# Gatwick Airport Northern Runway Project

Statement of Common Ground Between Gatwick Airport Limited and Tandridge District Council

DATE: MARCH 2024

Application Document Ref: 10.1.9

Diagram 3.3.1: Model performance before and after adjustment, Generic zone

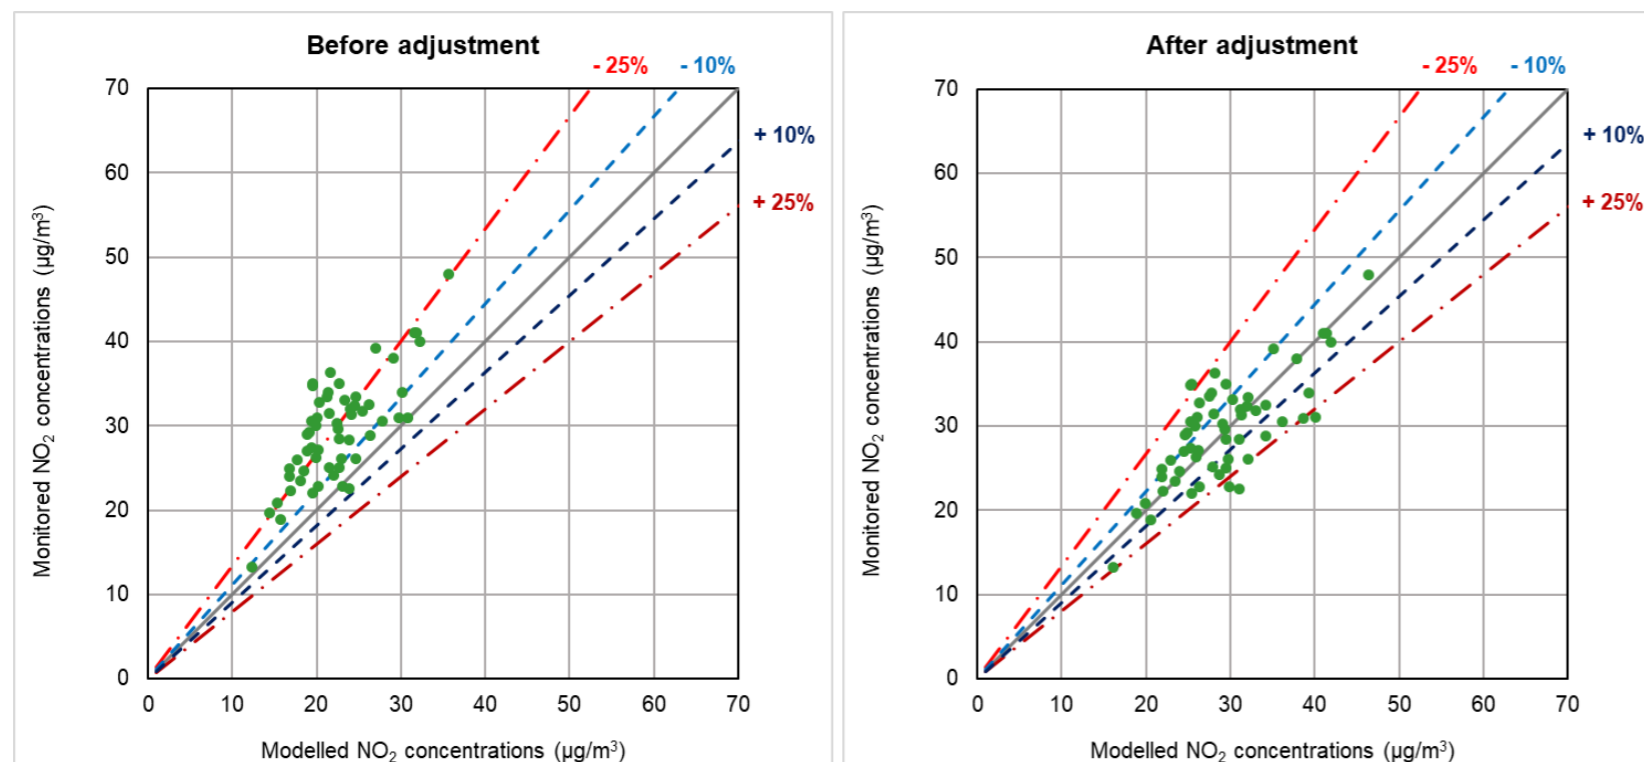
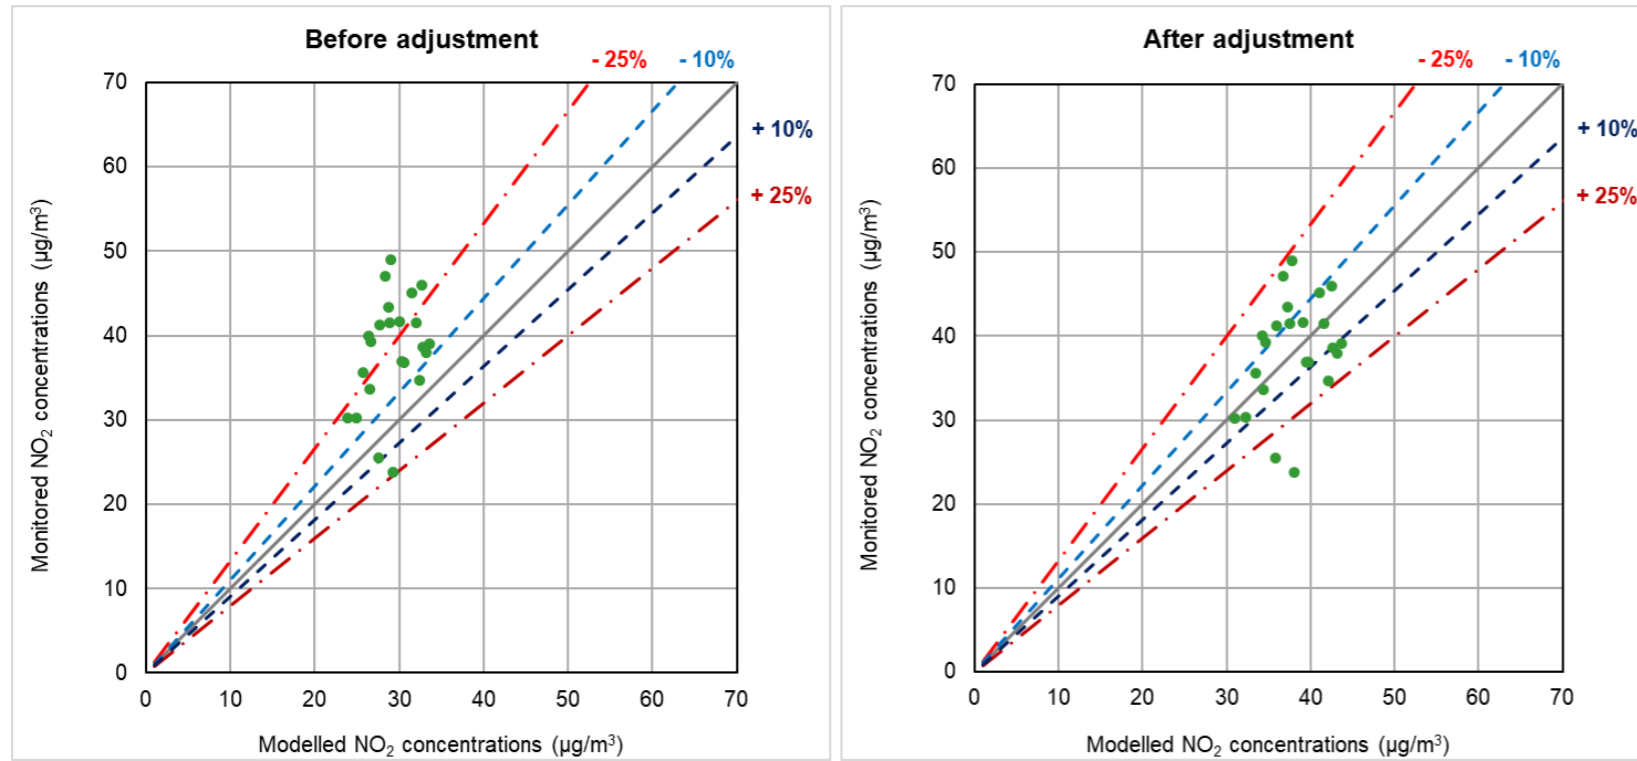
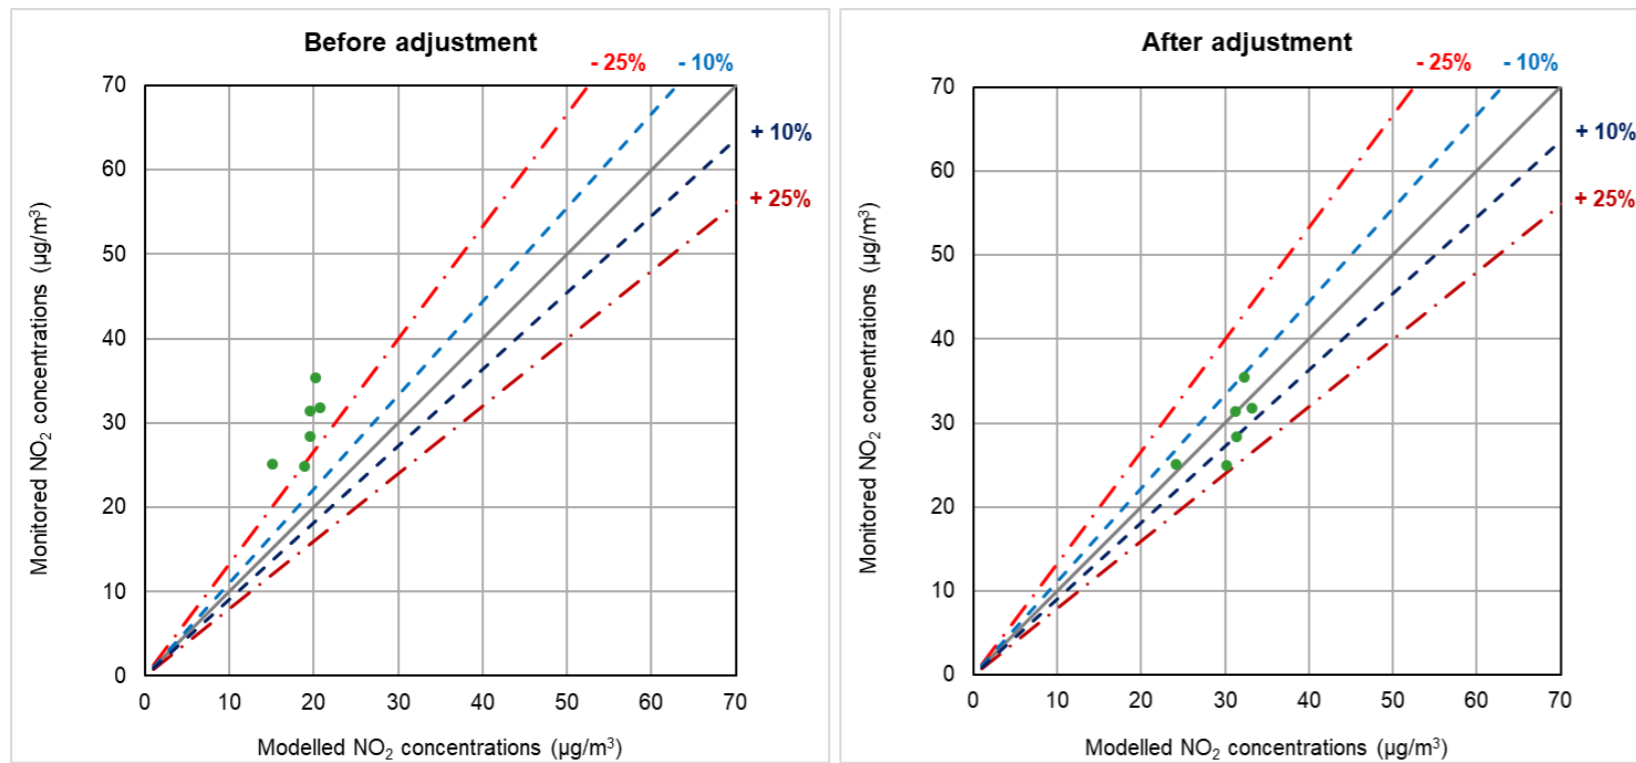
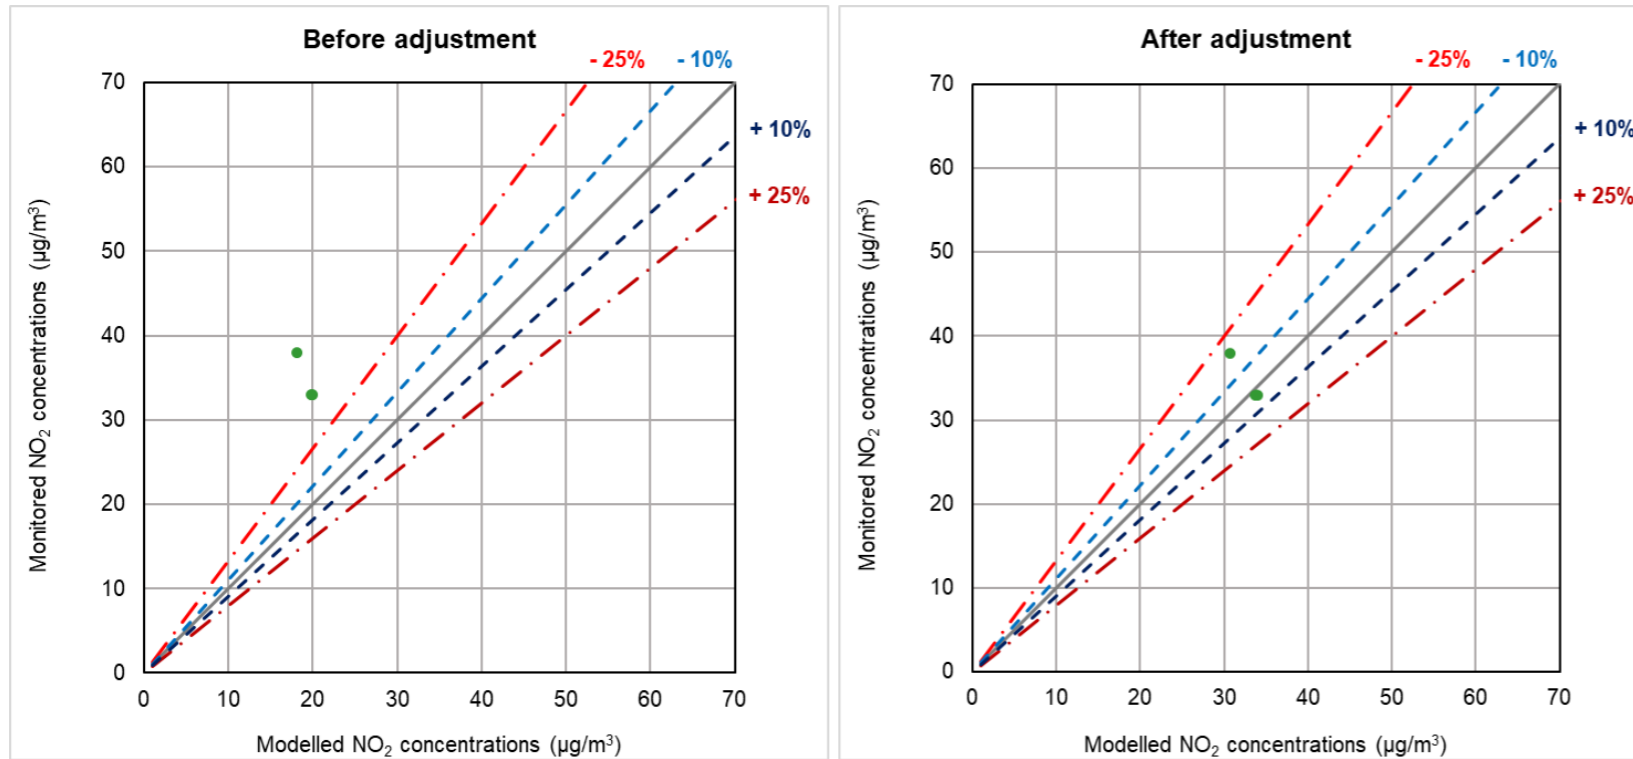
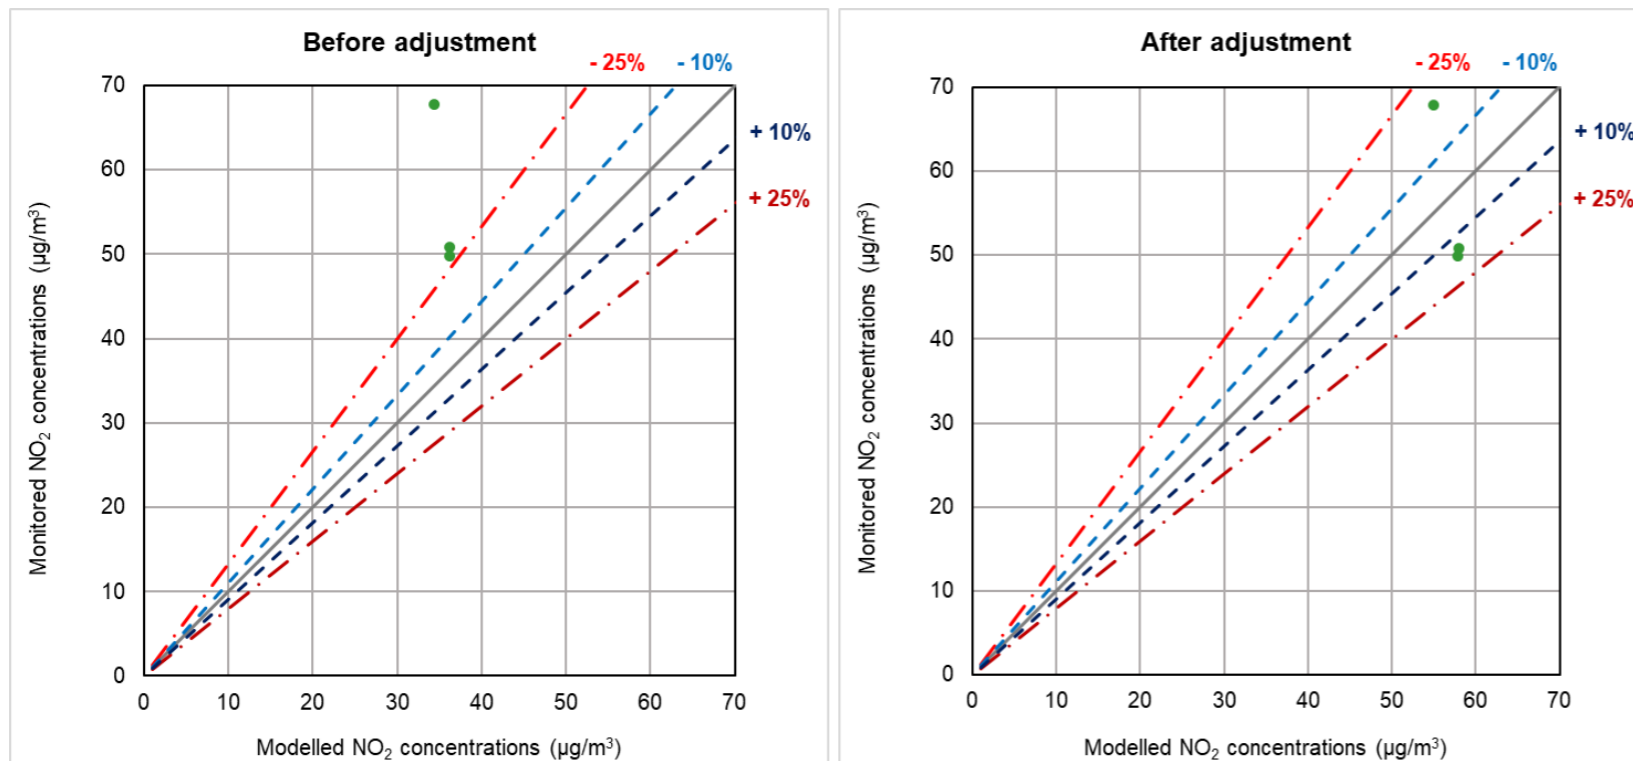
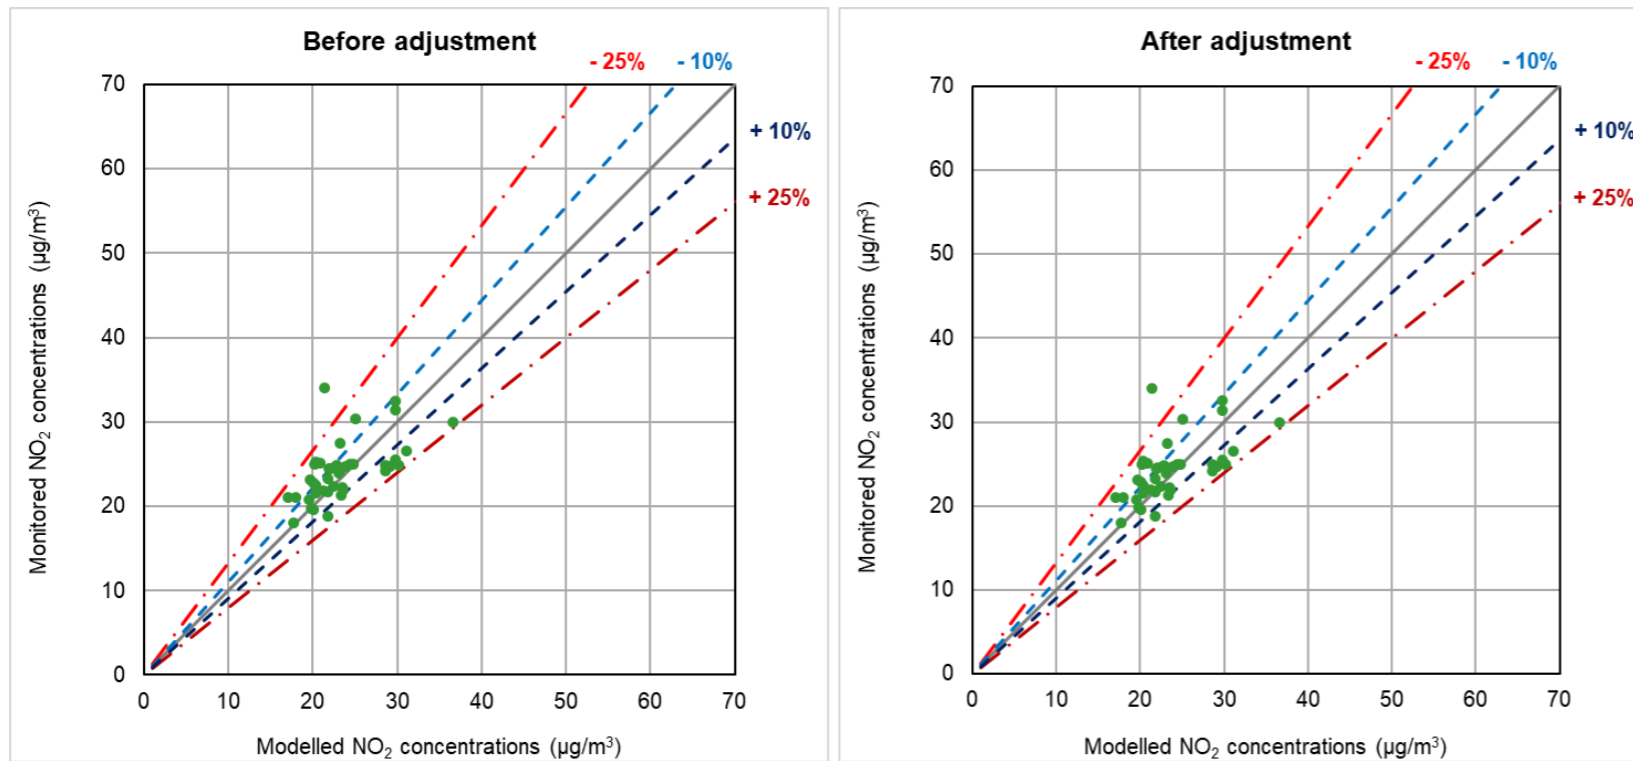
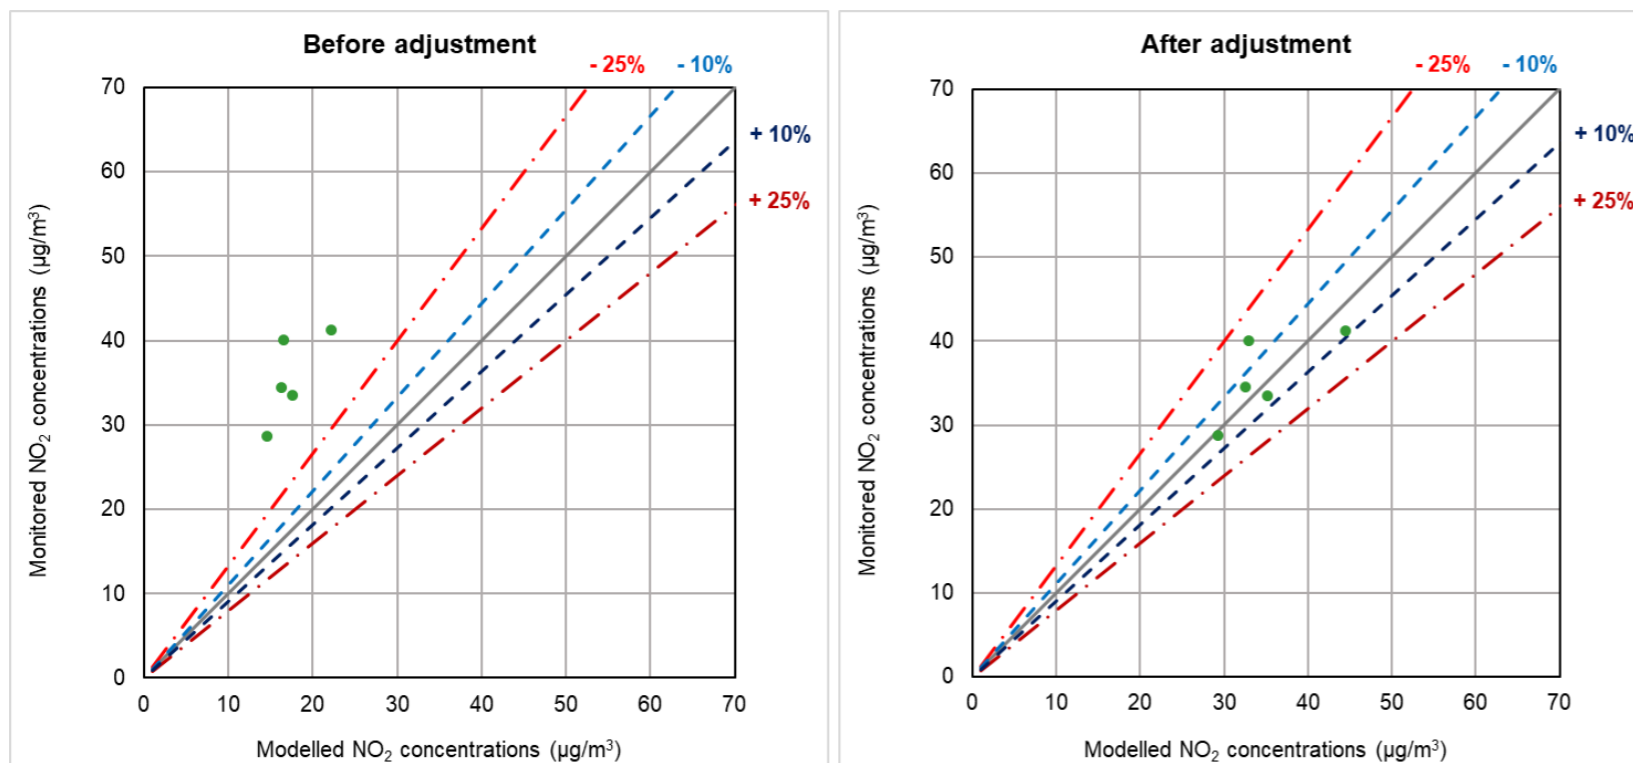
2.2.2.5	Verification zones	<p>TDC disagrees that enough justification was provided for the selection of different verification zones and why the model would be expected to perform differently in each area. A sensitivity test is required to demonstrate that the conclusions of the assessment would not change if a single verification factor were used.</p> <p><b>Updated position (Deadline 1):</b> Further discussion is required on this point and the request for a sensitivity test examining the use of a single verification factor still remains.</p>	<p>Full details of the model verification process are included in Section 3 within the ES Appendix 13.6.1. Table 3.3.1 provides details on the verification zones used.</p> <p>The verification methodology was agreed with local councils at the modelling methodology workshop in November 2022. Model files and results were provided to the TWG via email 18<sup>th</sup> August 2023.</p> <p>The process followed during the ES took into account feedback from the local authorities at the PEIR stage and following discussions on the agreed approach.</p>	<p><b>ES Appendix 13.6.1 Air quality Data and Model Verification</b> <a href="#">[APP-159]</a>,</p>	Under discussion
